The Member Secretary,
Chennai Metropolitan
Development Authority,
No.1, Gandhi Irwin Road,
CHENNAI -600 008.

Letter No. C 4/28213/2003

Sub: CMDA - Planning permission - Proposed
additional Construction of MGR Memorial
Charitable Trust at Door No.5 & 6, R.S.
No.4274/13, Block No.97 of Mylapore
Village - Development Charges and other
Charges to be remitted - Regarding.

SITE PLAN SCALE 1" = 40'

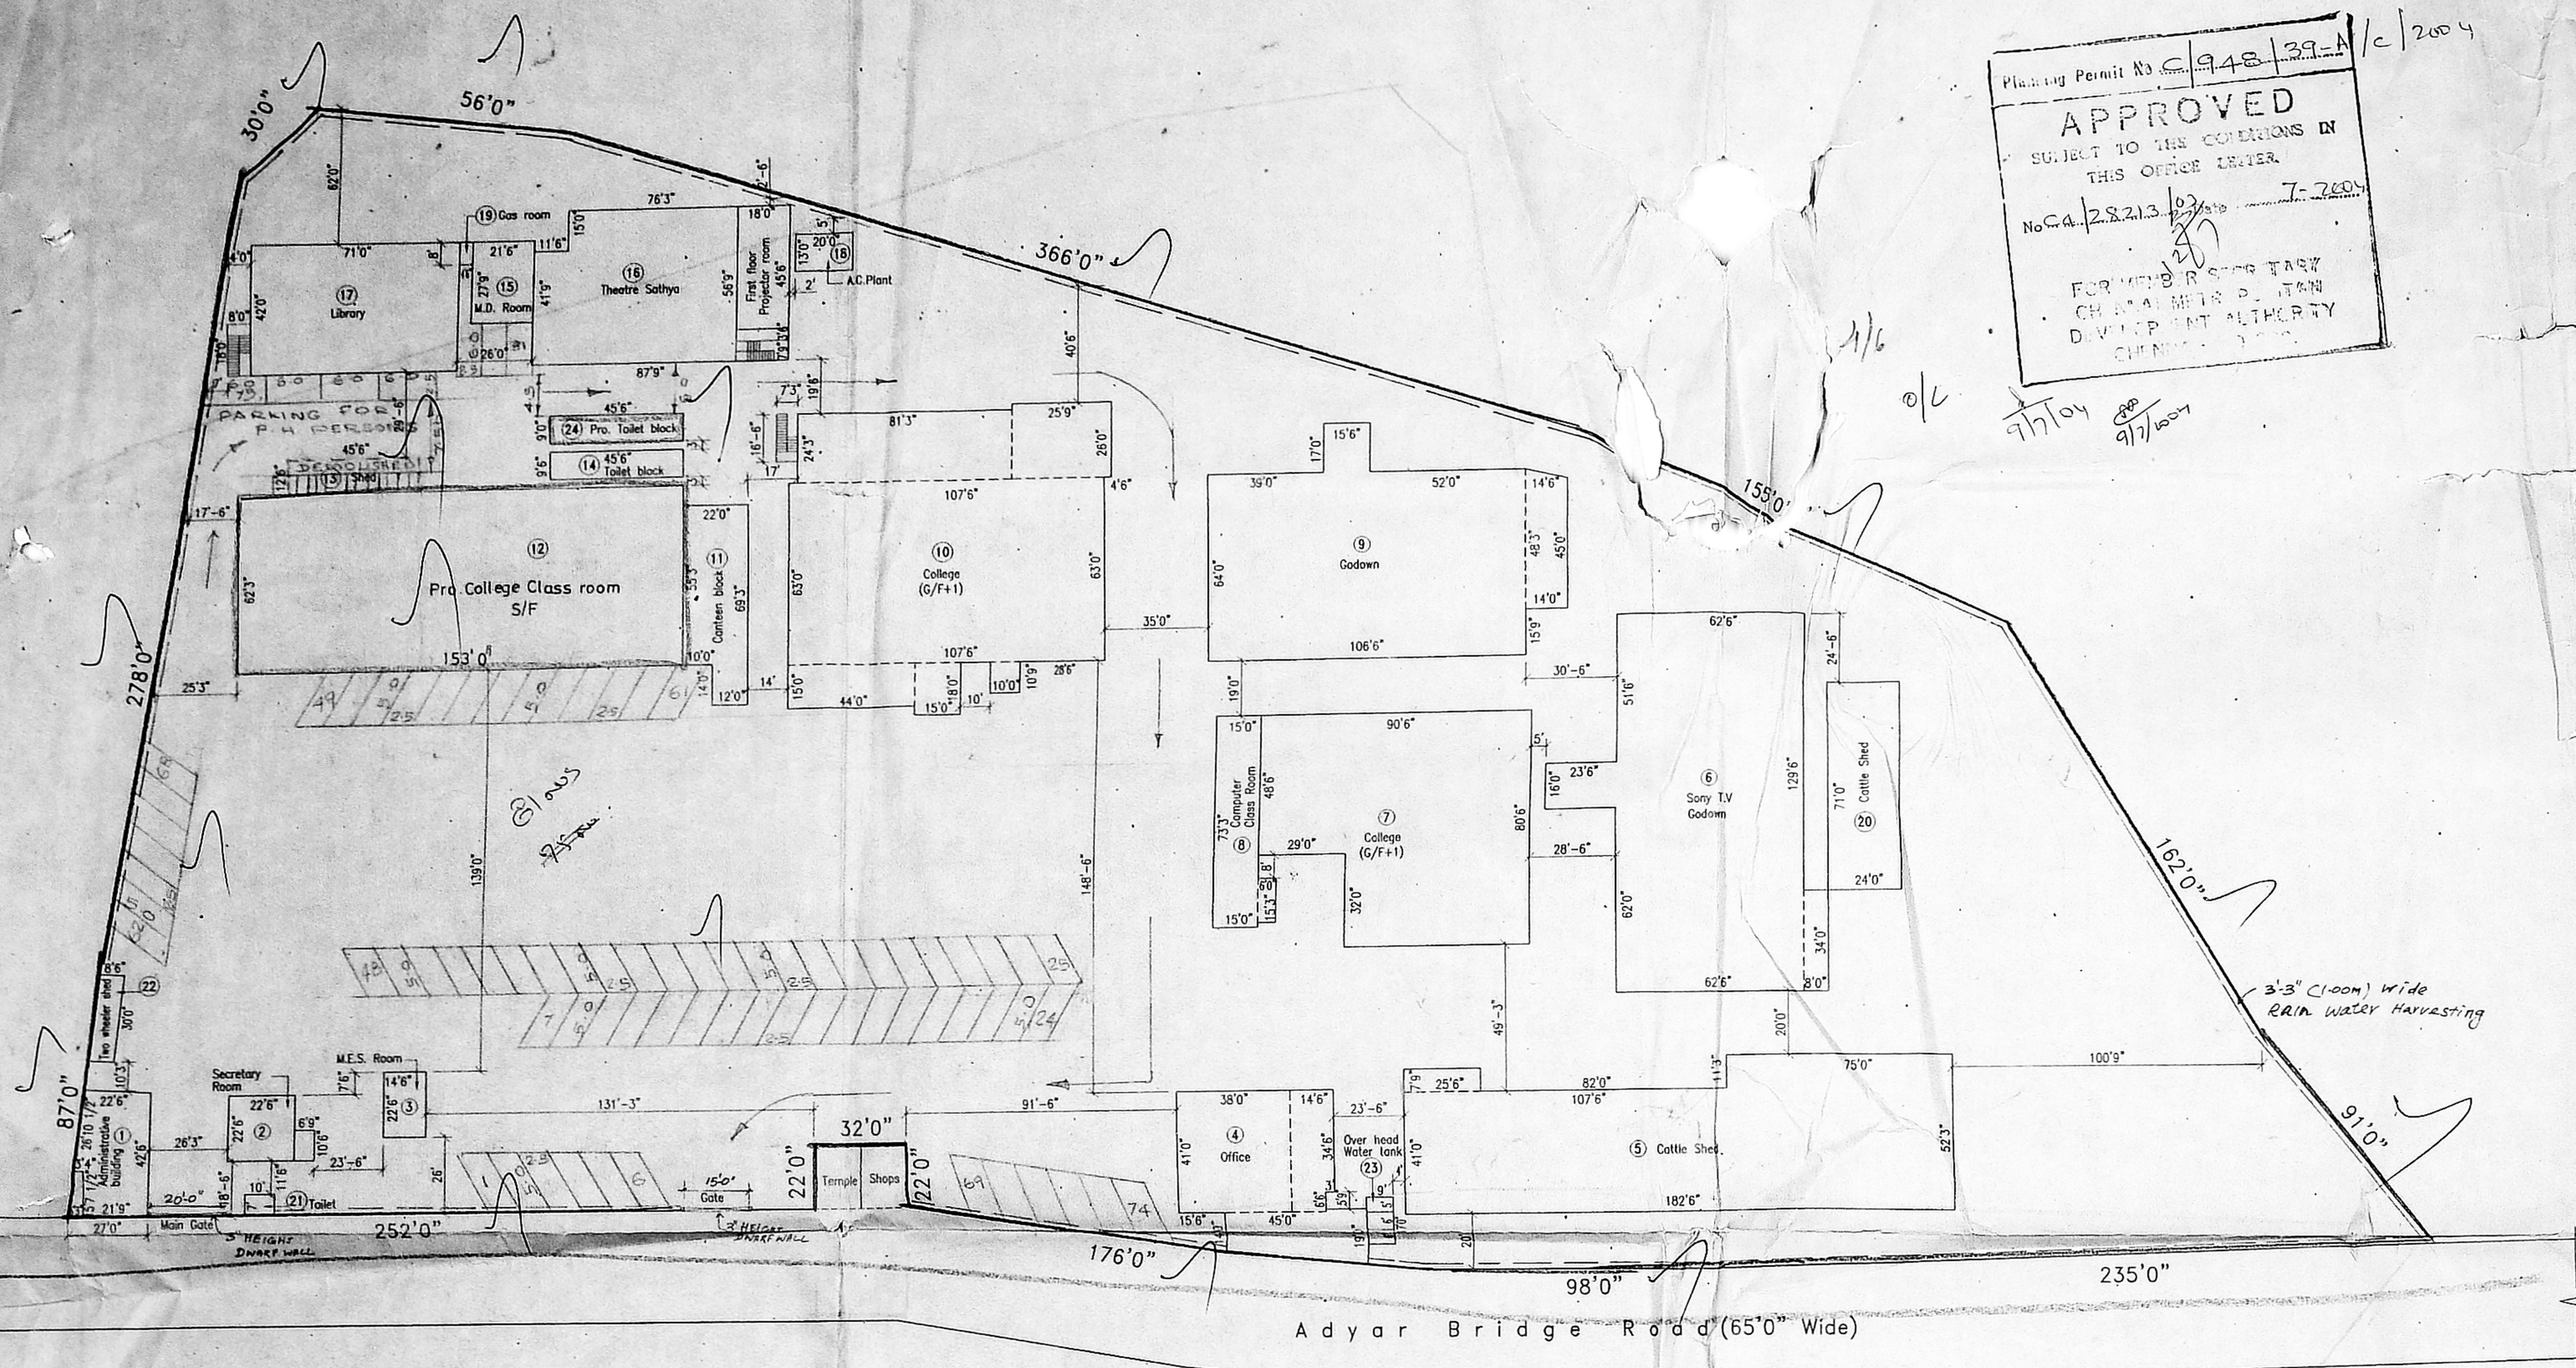
b) Balance 52 car parking complying driveway turning radius and parking lot size as per Development Control Rule.

19 PRO. SECOND FLOOR PLAN

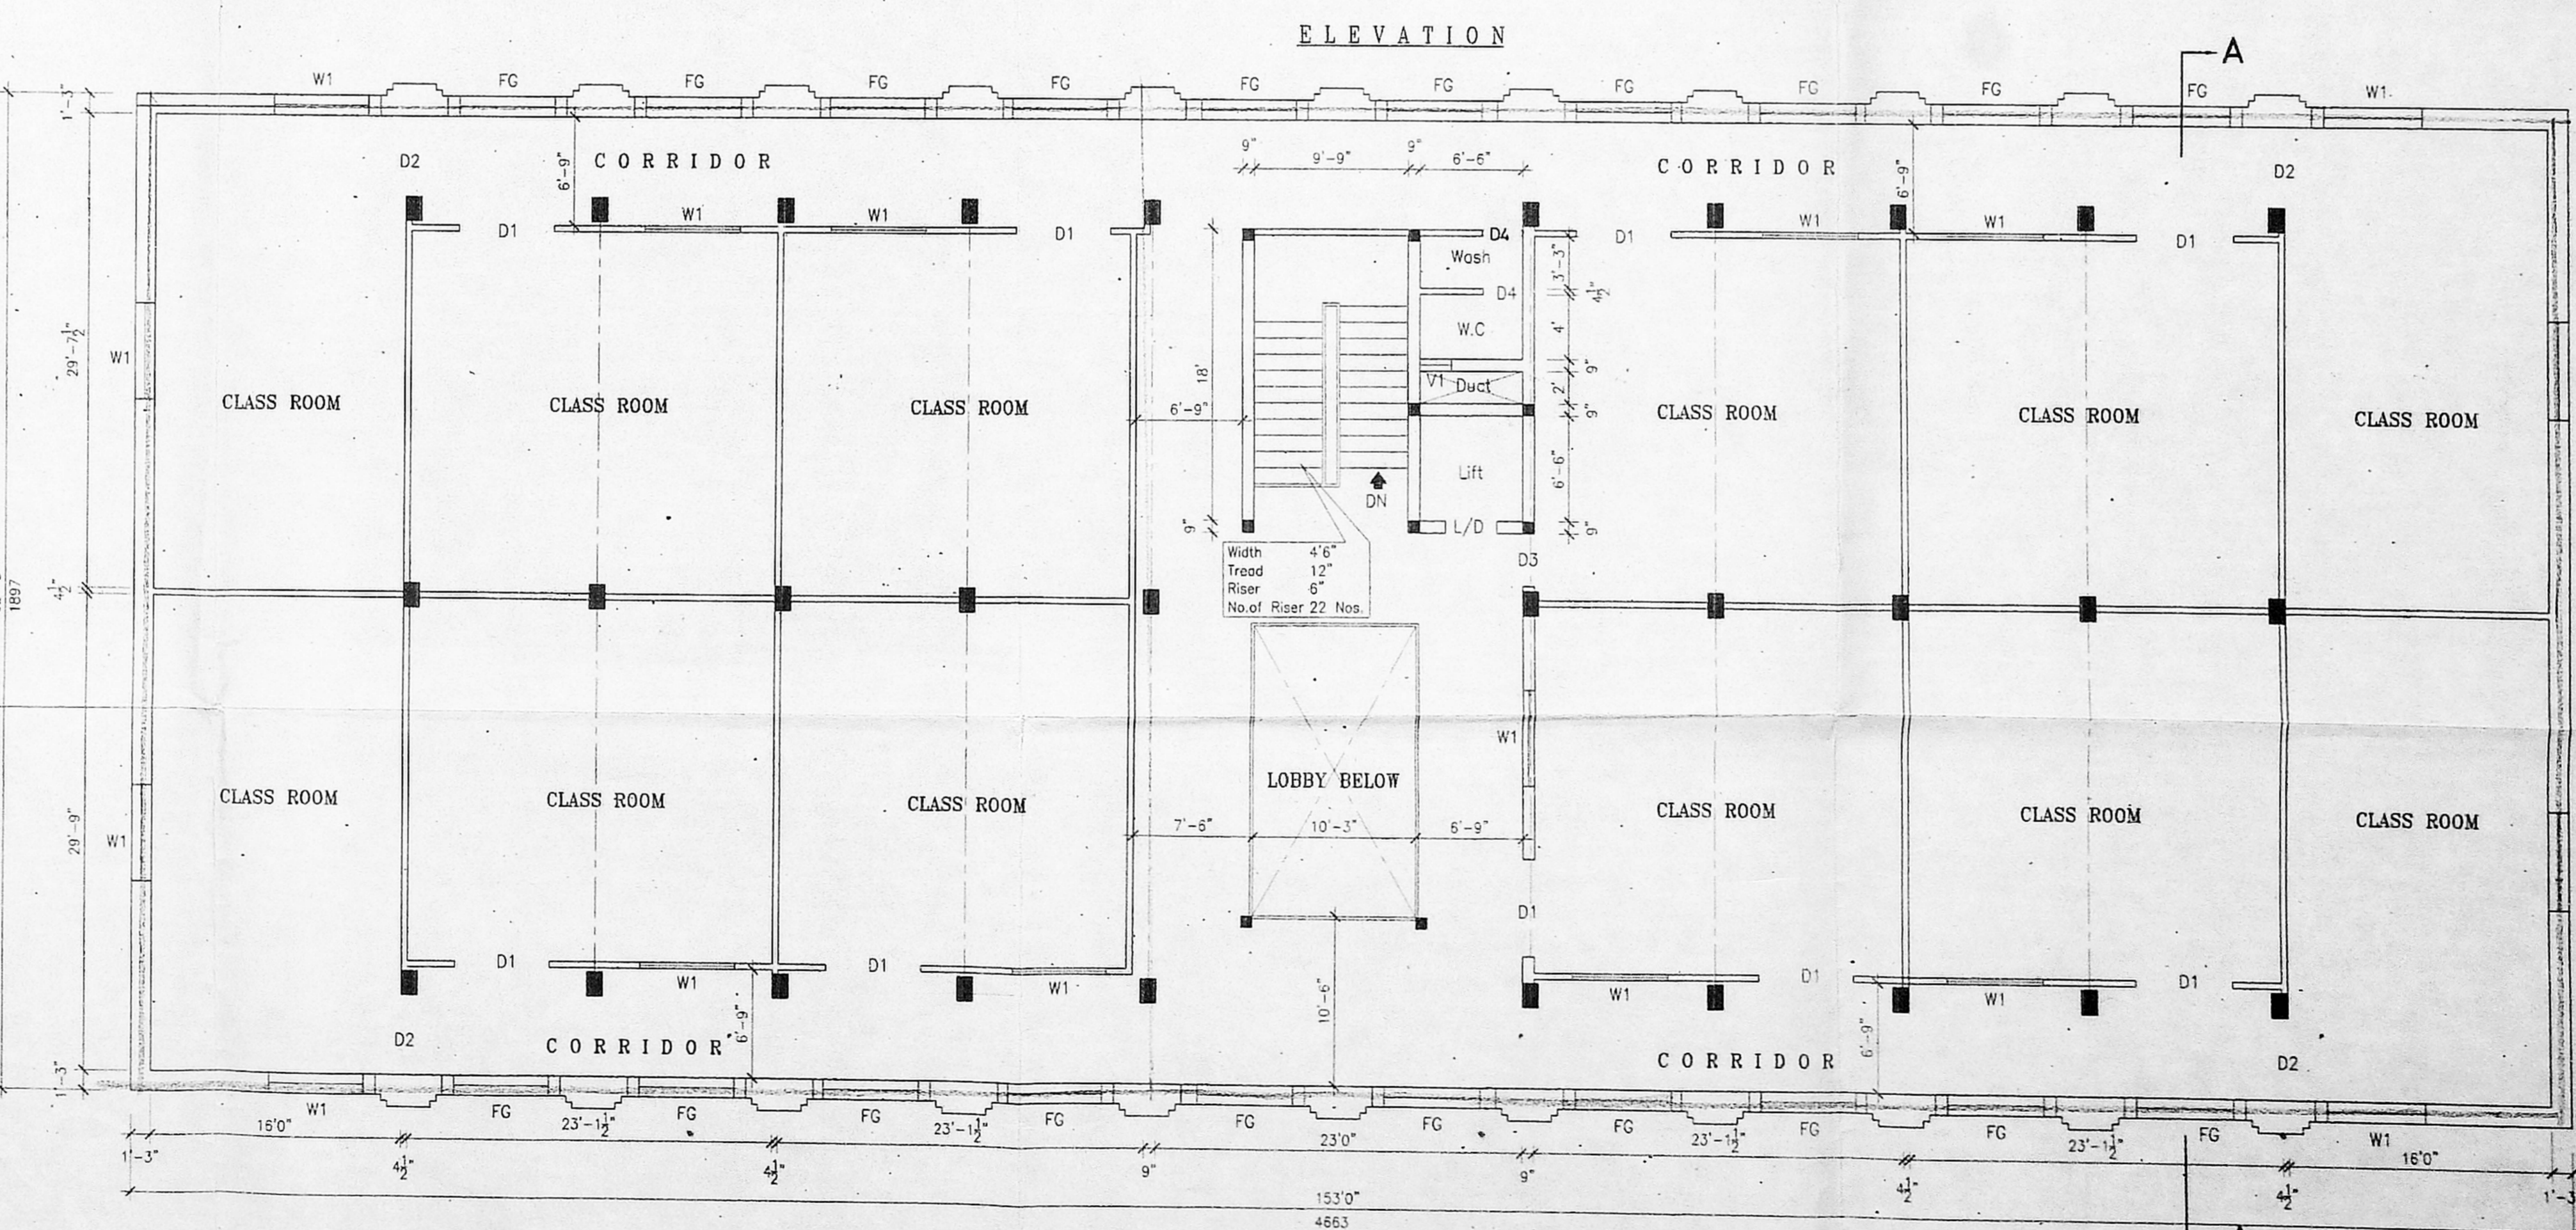
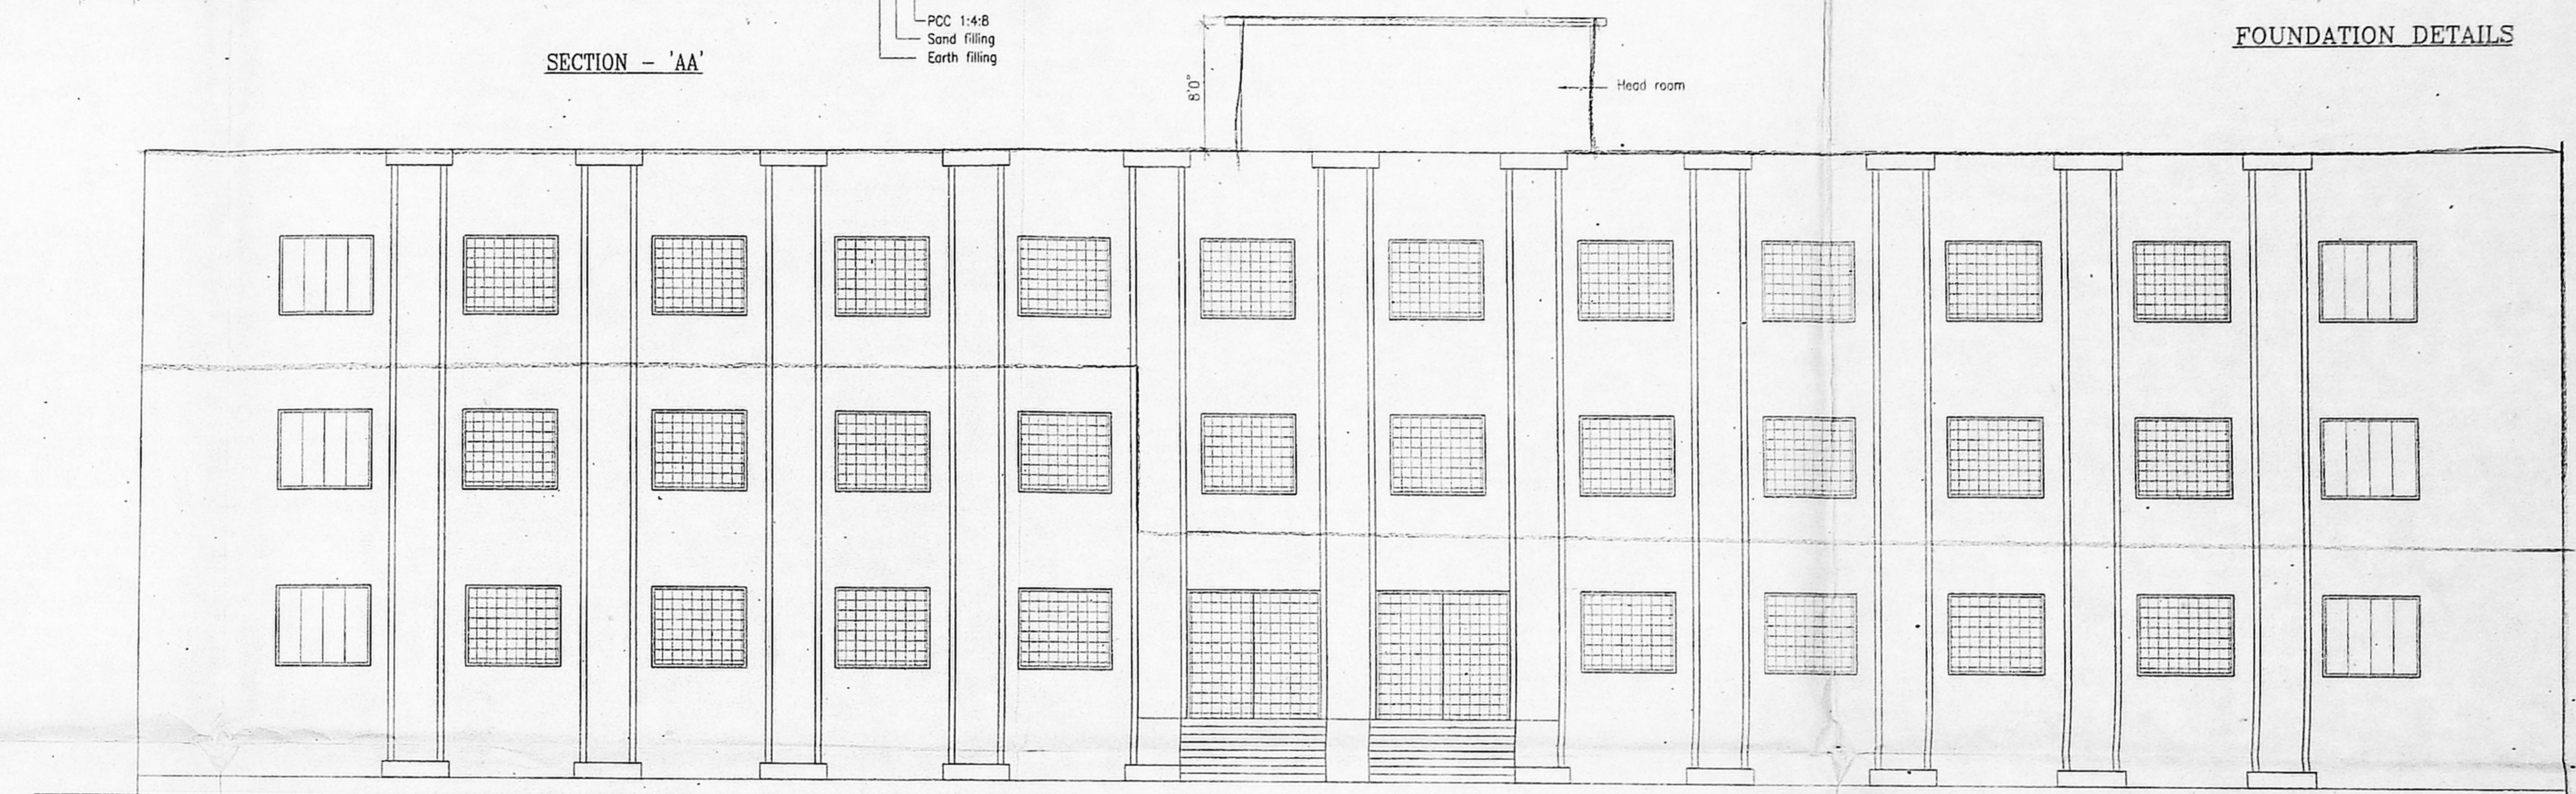
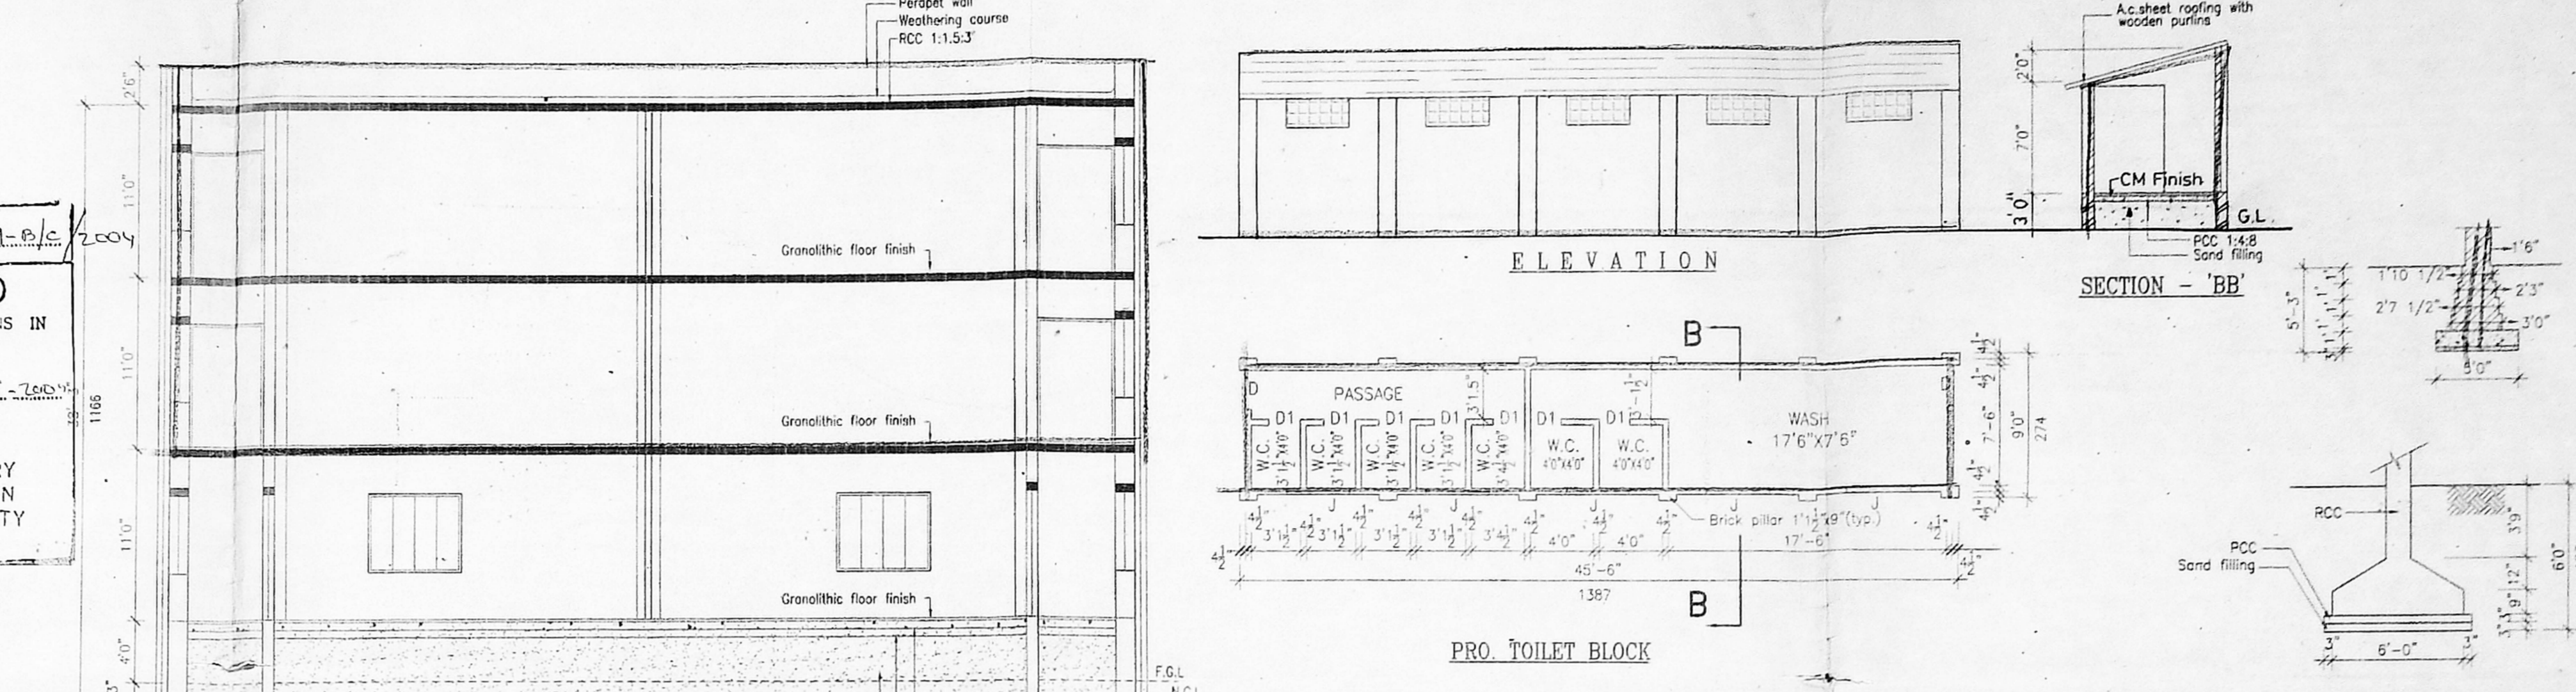
Special Toilet, Ramp 1:12 and handrail at 0.90m and 0.75, height and 10% of required carparking shall be reserved for the physically handicapped near the entrance.
